**Consultation Response from KC,
Highways Development Management**

2025/93126 The Coach & Horses, Eastgate, Honley, Holmfirth, HD9 6PA

**Demolition of rear block, erection of rear extensions and alterations to existing building to form
9.no apartments including associated works and alterations (within a Conservation Area)**

Date Responded: 3-12-2025.

4 Proposed Site Area  
 1 : 200

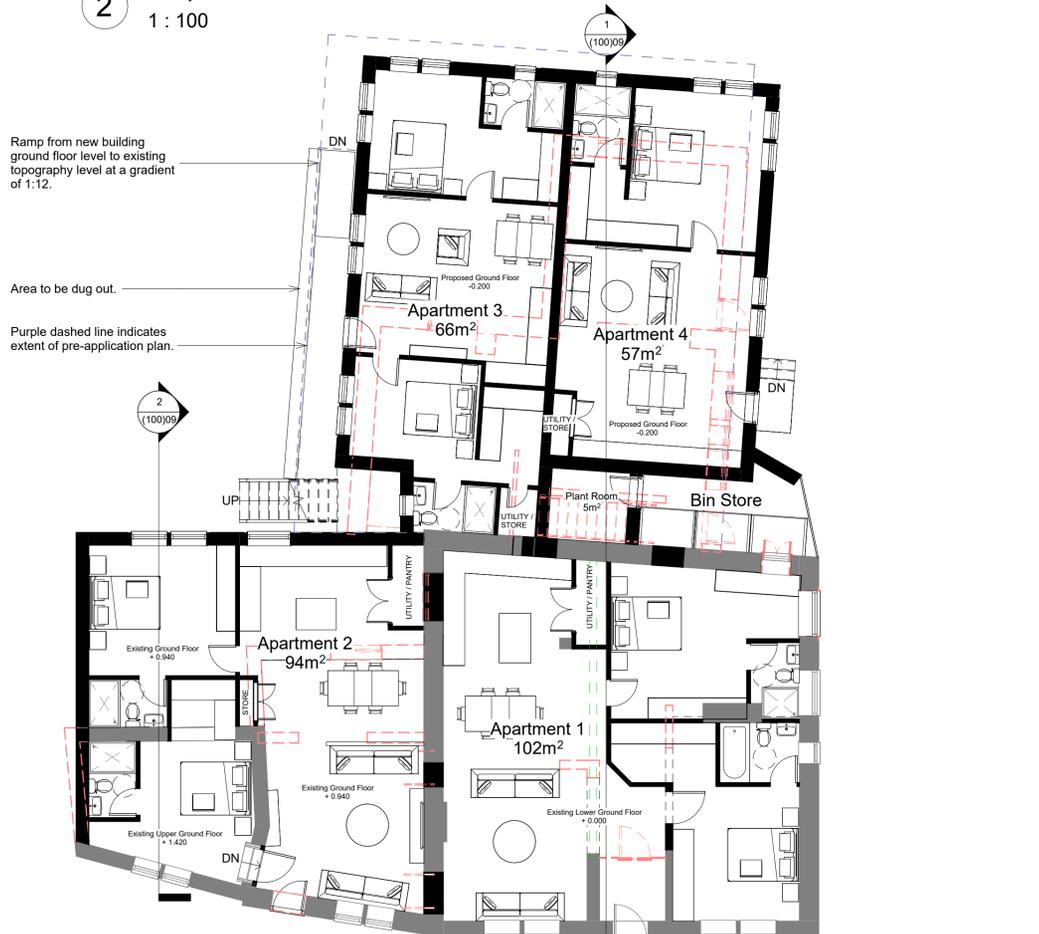
The existing accesses onto Eastgate are to be retained IN and OUT along with the existing car park to the rear. The car park is shown to have 12 off-street parking spaces. The proposals include a bin collection area to the site frontage and a cycle store within the site.

Whist both accesses from the site onto Eastgate are sub-standard, it is considered that a residential development of just 9 apartments would generate less traffic than the former use as a public house and Highways Development Management have no object to these proposals.

Before the development is brought into use the ingress and egress shall be signed and lined 'IN' and 'Out' in accordance with details that have been approved in writing by the Local Planning Authority. The signs and lining approved shall thereafter be retained.

Prior to the development being brought into use, the approved vehicle parking areas shall be surfaced and drained in accordance with the Communities and Local Government; and Environment Agencies 'Guidance on the permeable surfacing of front gardens (**parking areas**)' published 13th May 2009 (ISBN 9781409804864) as amended or superseded; and thereafter retained throughout the lifetime of the development.
